Application Ref:	2025/0937			 Ribble Valley Borough Council www.ribblevalley.gov.uk
Date Inspected:	N/A	Site Notice:	N/A	
Officer:	EP			
DELEGATED ITEM FILE REPORT:				APPROVAL

Development Description:	Certificate of Lawfulness for proposed rear dormers.
Site Address/Location:	Holly House, 8 Station Road, Rimington BB7 4DR.

SHEET: PROPOSED DORMER  
OPTION 2

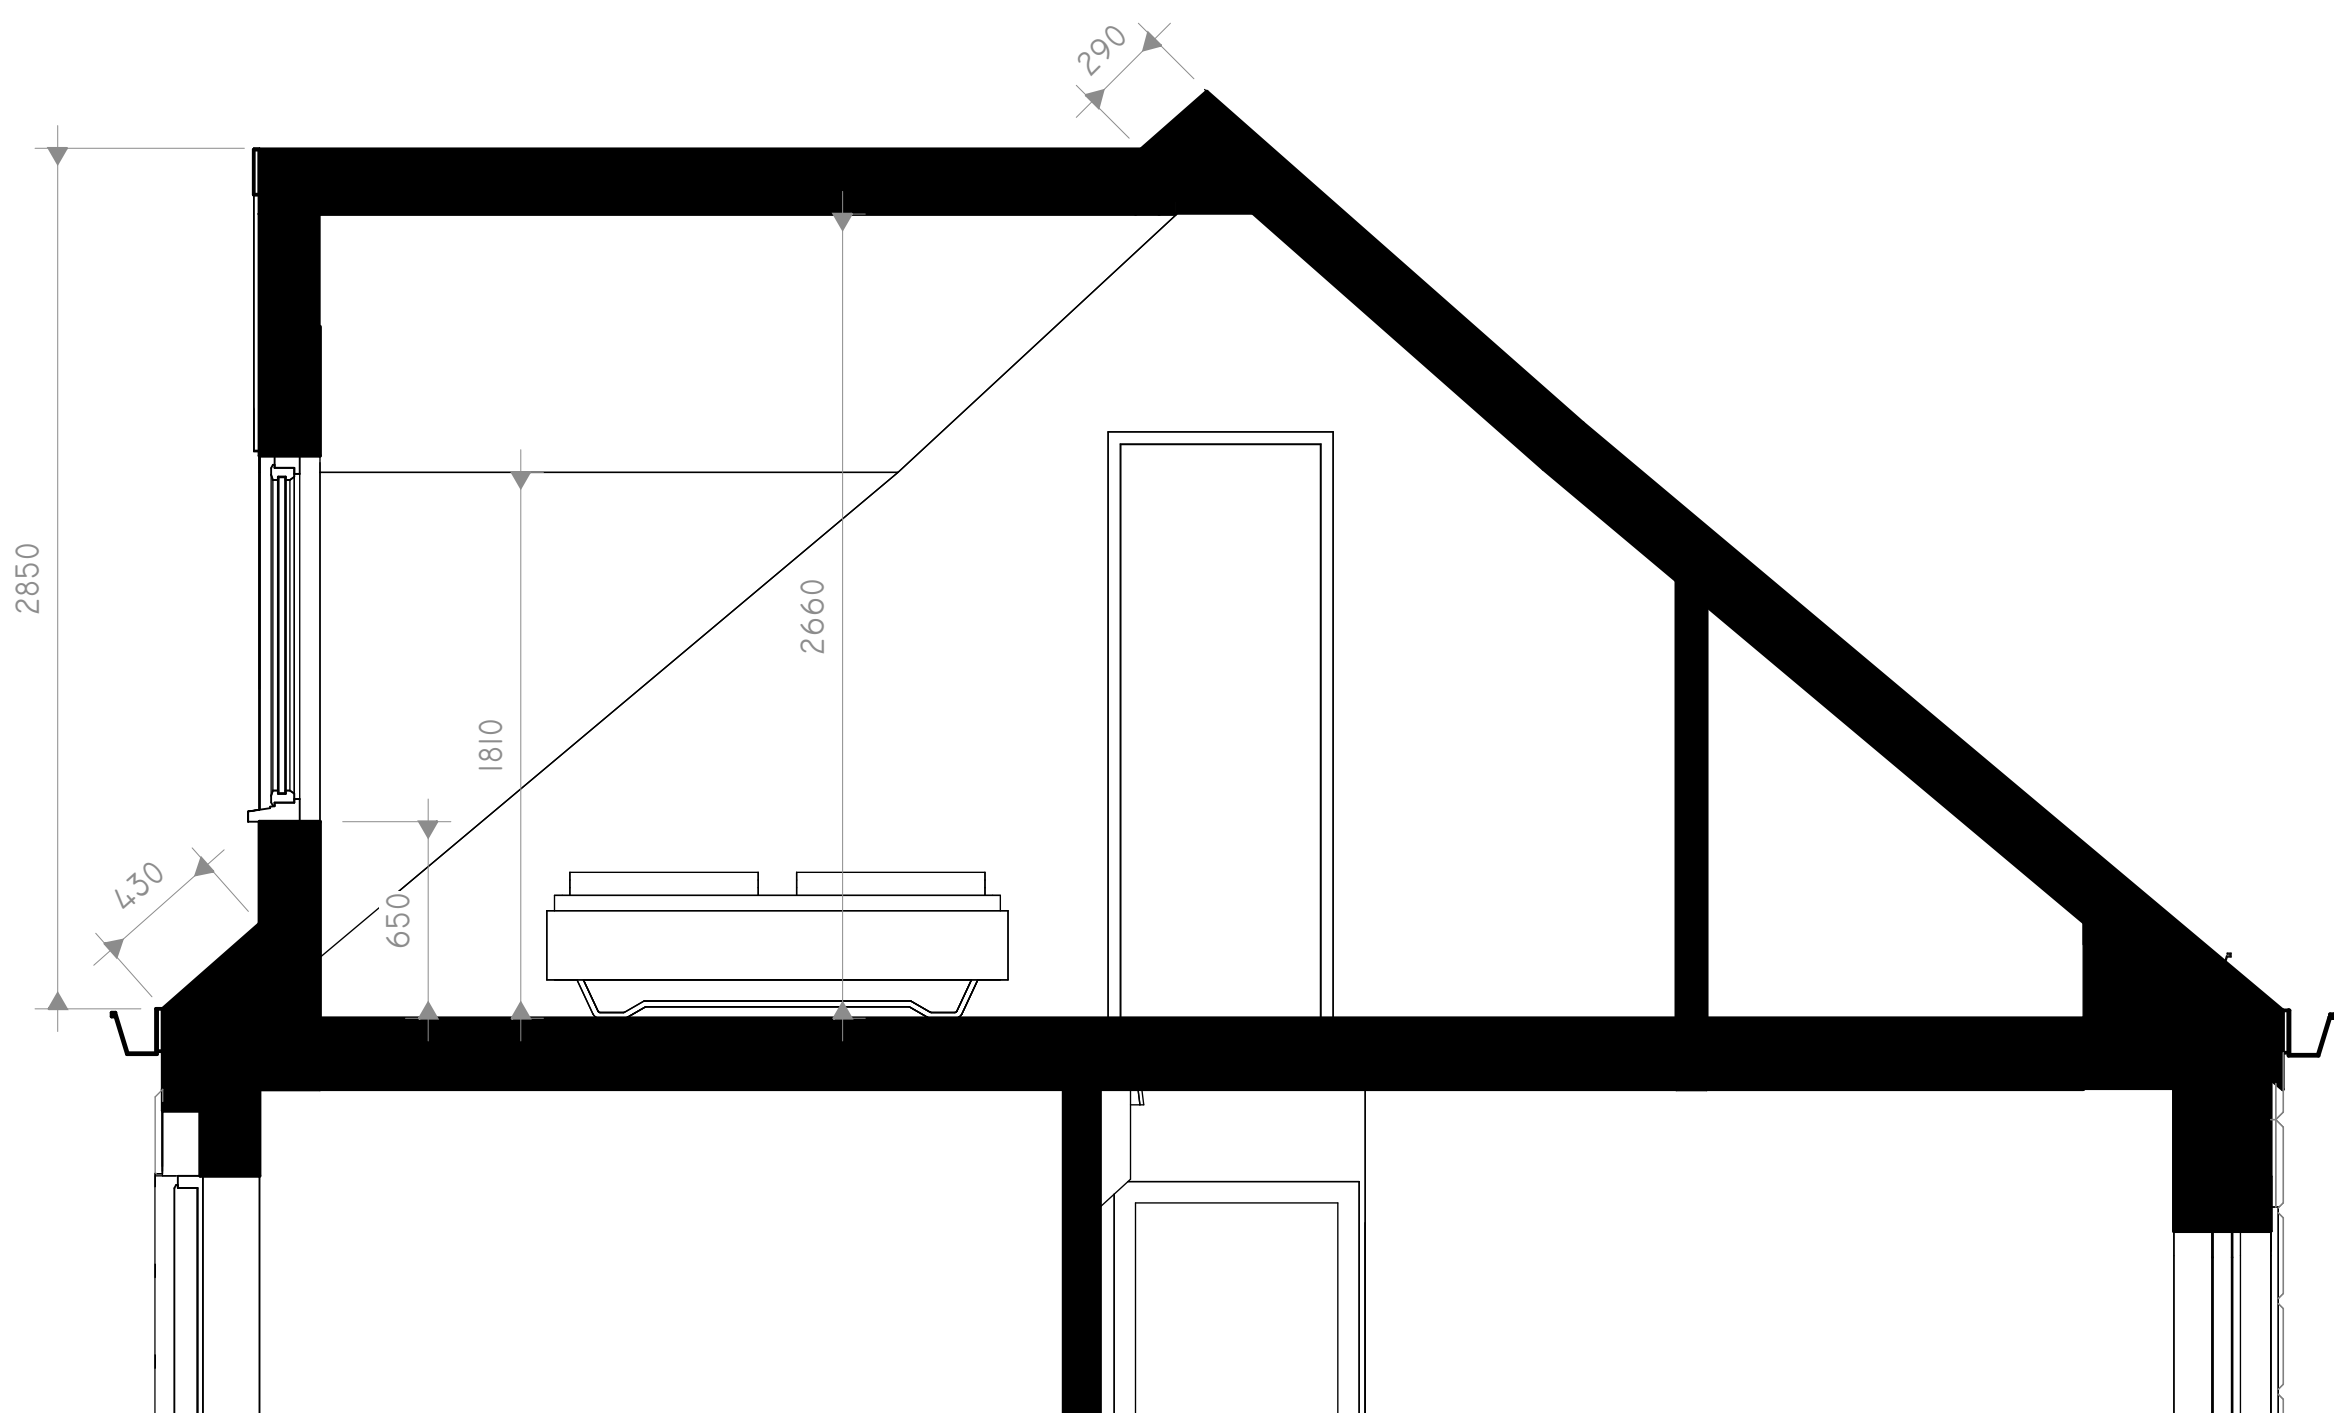
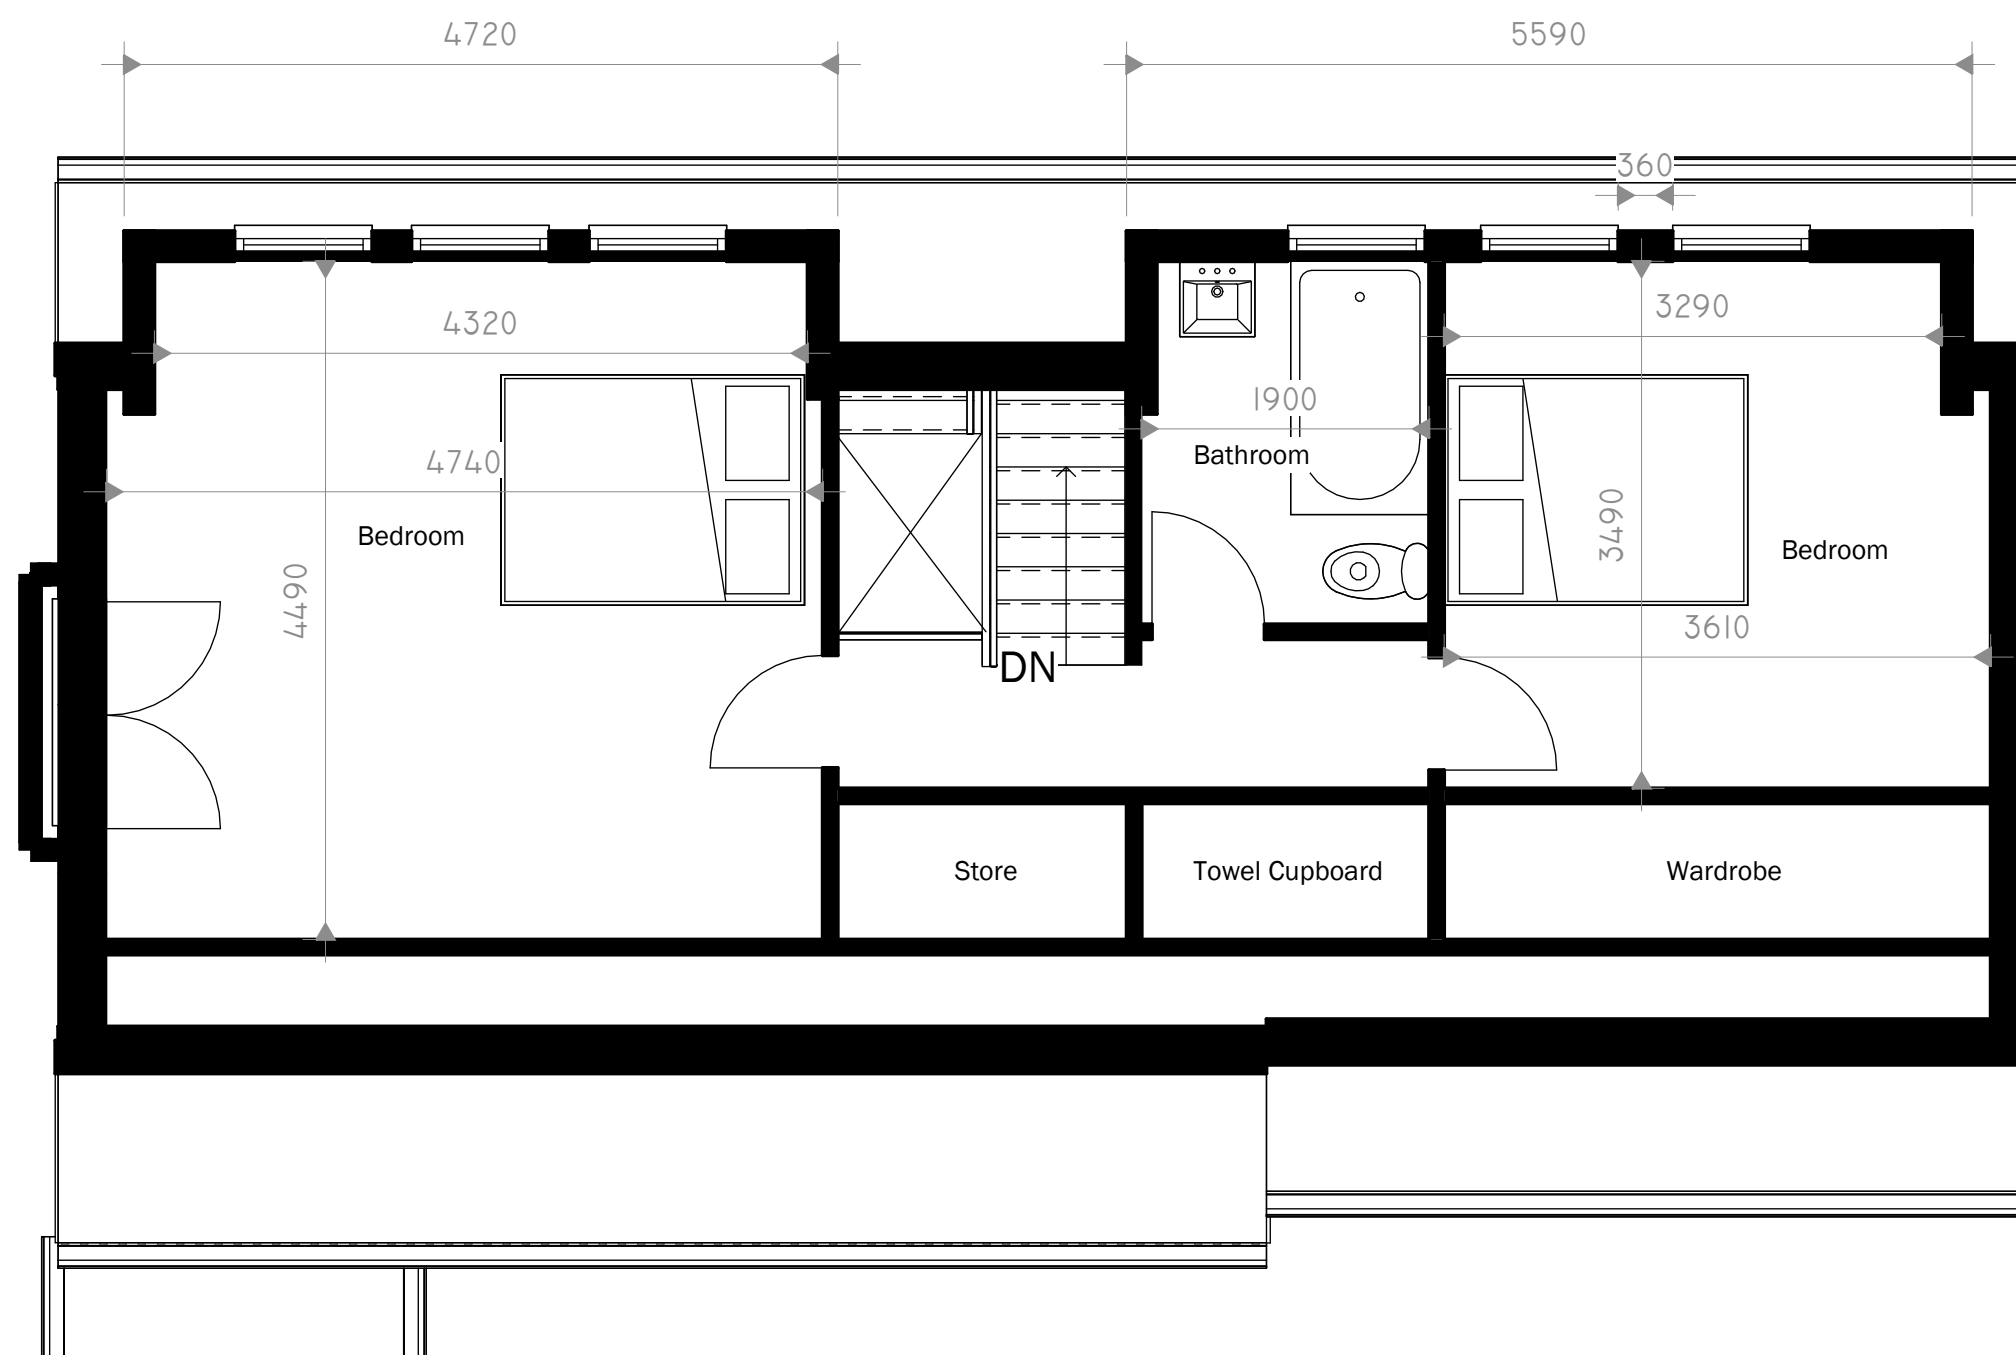
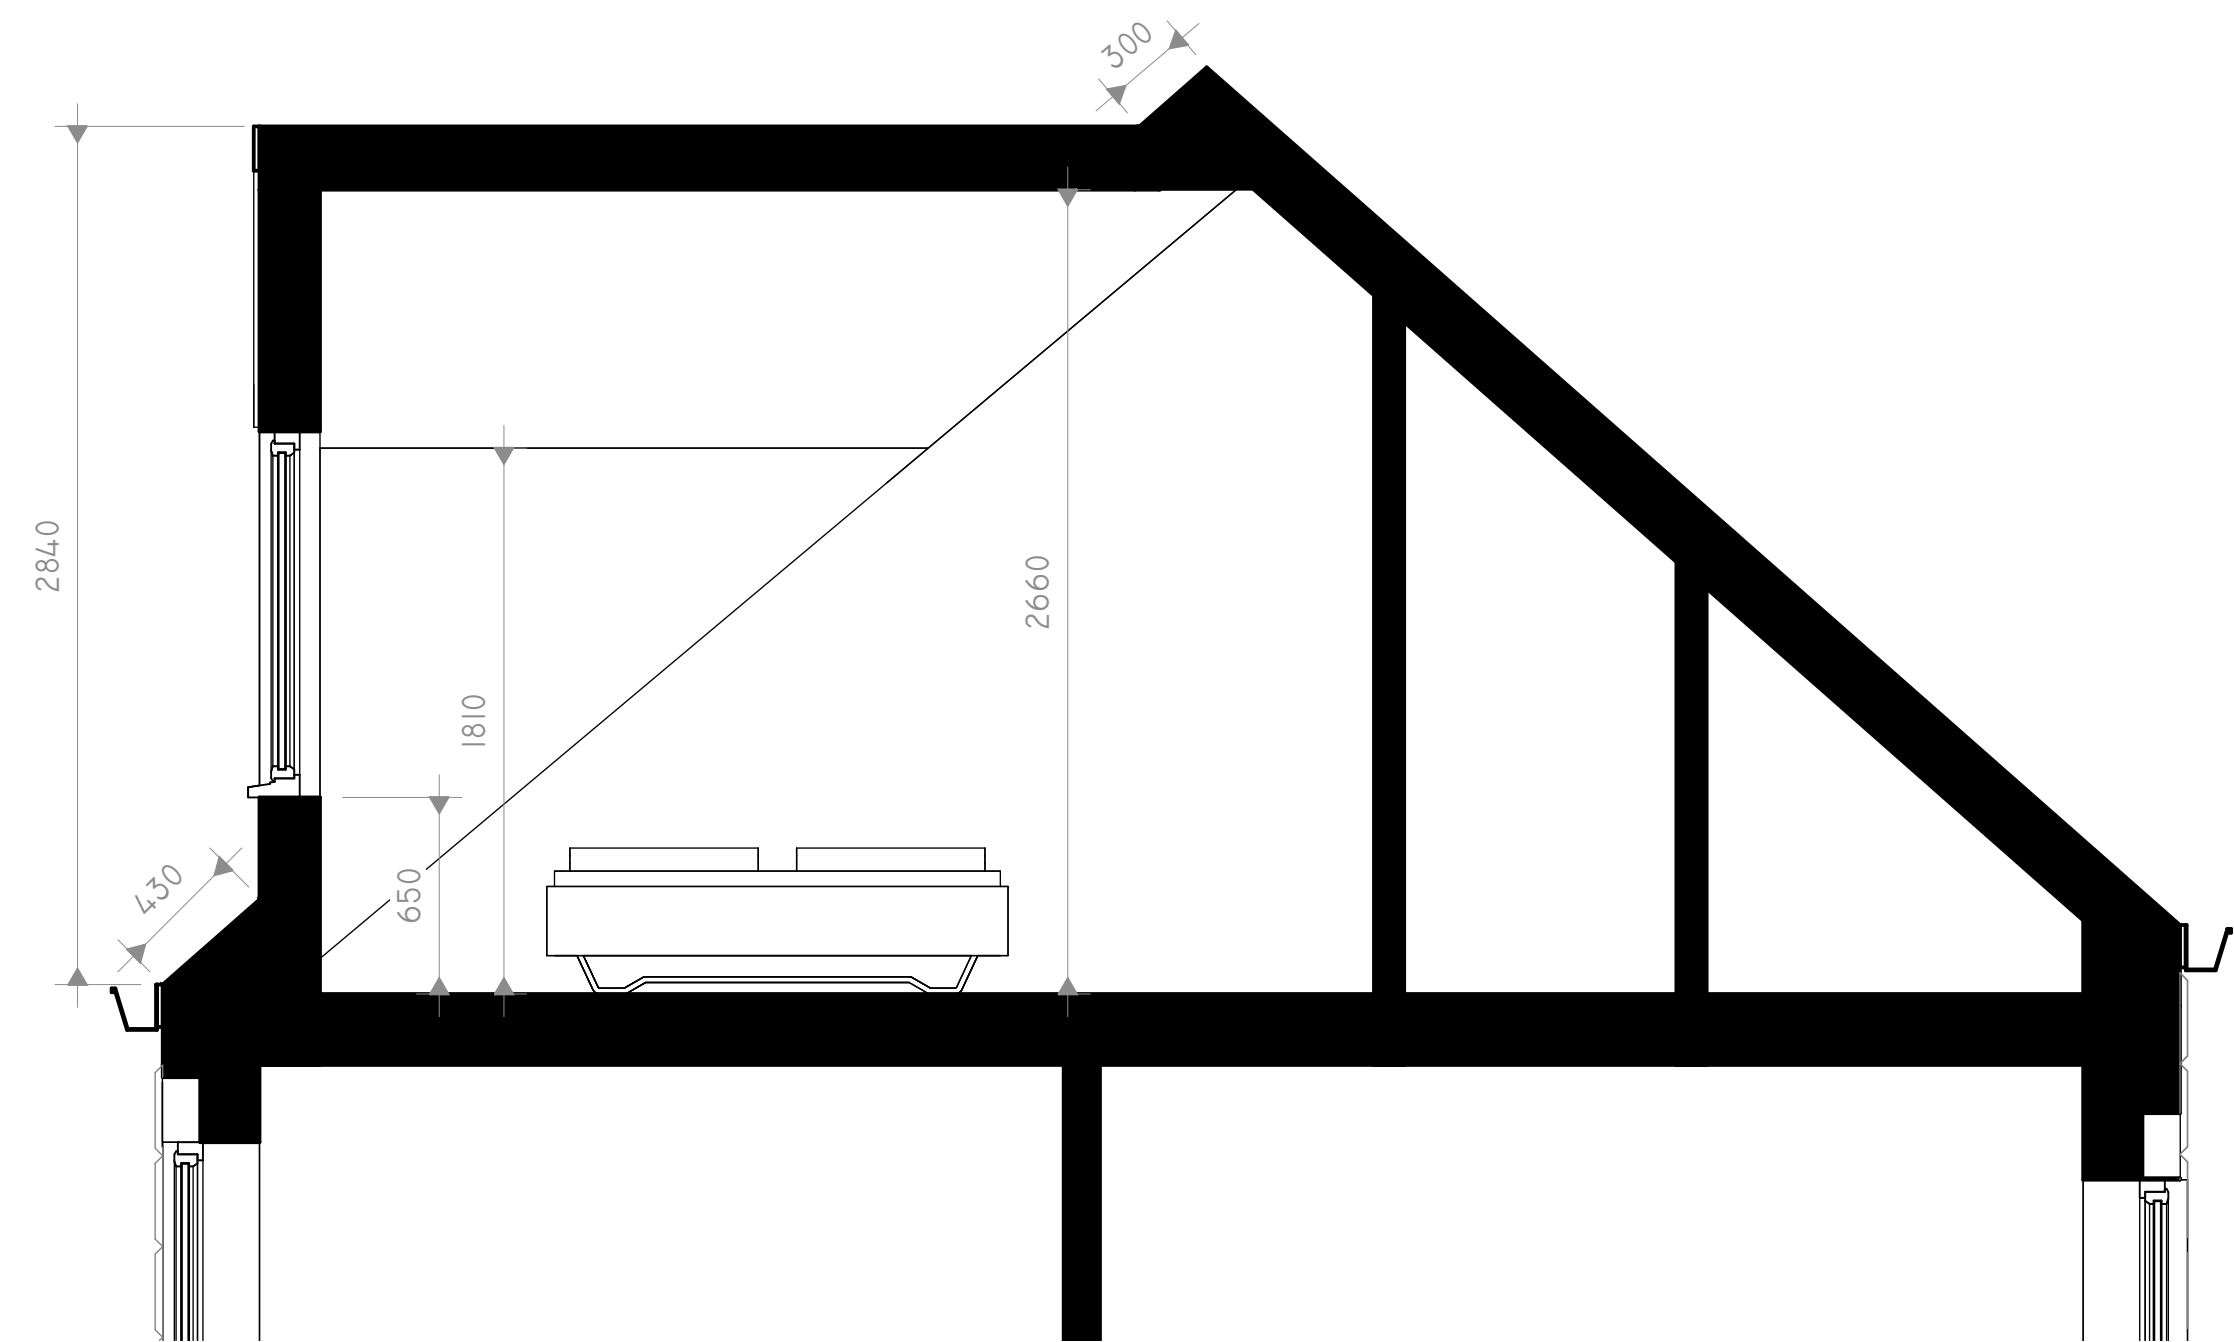
The proposed dormer extension would not exceed the highest part of the existing roof.

The existing dwelling has consent for a roof lift which increases the original roof volume by 18 cubic metres. The proposed dormer extensions will increase the original roof by a further 27 cubic metres. The overall increase is therefore 45 cubic metres and compliant with the above.

The proposal meets the 0.2 metre criteria.
